**OXFORDSHIRE COUNTY COUNCIL'S RESPONSE TO CONSULTATION
ON THE FOLLOWING DEVELOPMENT PROPOSAL**

Application no: 22/02647/F

Proposal: Planning Application for Development within Use Classes E (g) (i), and/or (ii), and/or (iii), and/or B2 and/or B8 and Associated Works including Access and Parking

Location: Unit 8 4B, Oxford Technology Park, Technology Drive, Kidlington, OX5 1GN

content: BUILDING 6
PROPOSED CYCLE LOCATIONS
date: JUNE 2022

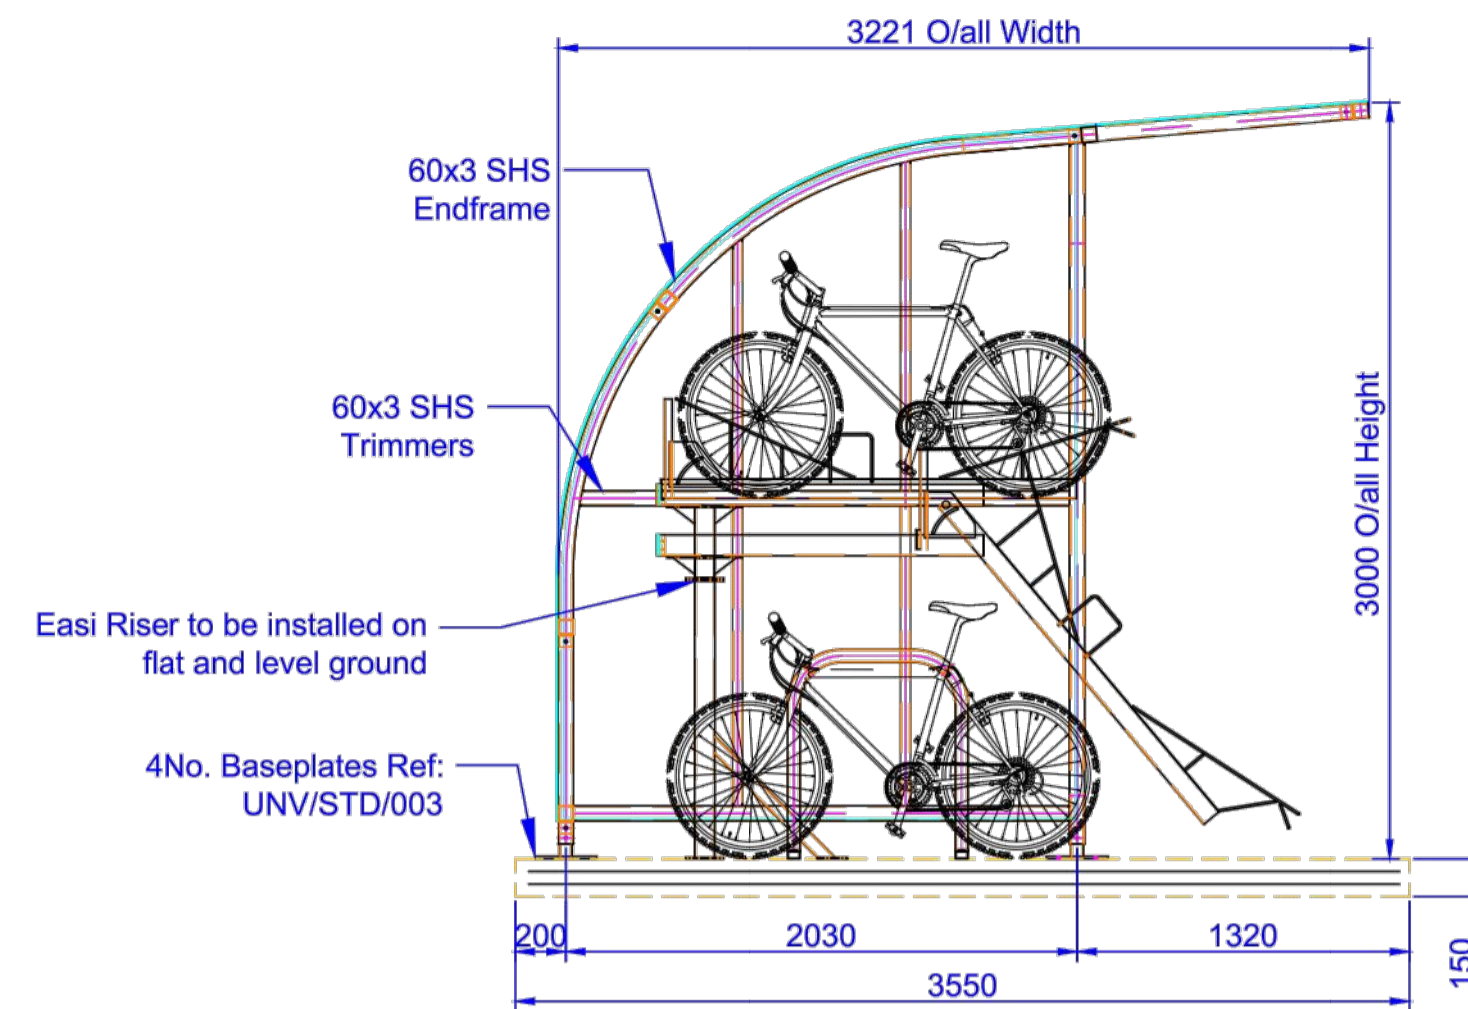
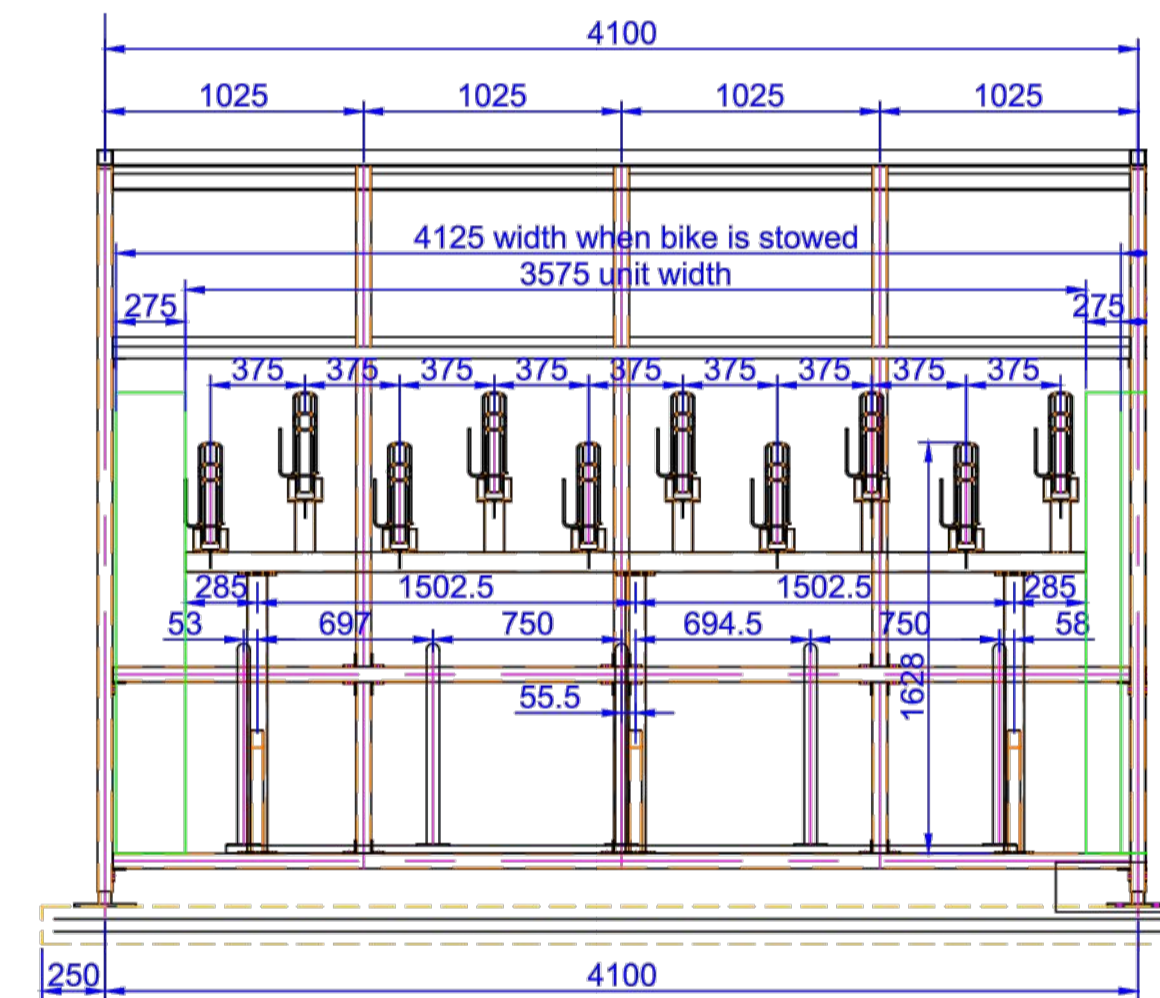
The Highway Authority had previously also objected to the proposed use of double decked cycle parking. OCC's recently adopted Parking Standards advise against the use of double decked cycle parking as it can be difficult for all users to raise and lower cycles from the upper rack.

- *Cycling parking is to be provided in a convenient location close to building entrances and bus stop locations. Such provisions are to be covered, lit (where appropriate) and in the style of a Sheffield stand, which are individually installed permanently into the floor material (e.g. not toast-rack style stands bolted to the floor).*

• *Double decked or vertical cycle parking should not be used unless agreed by OCC in specific circumstances.*

It has since been pointed out that double decked cycle parking has been used throughout the wider Oxford Technology Park development and that a precedent has been set for their use on the site. I have also been made aware that the upper racks on the neighbouring units have been used even while spaces are available on the lower level.

I therefore consider that, in this instance, OCC can agree to the use of double decked cycle parking spaces.
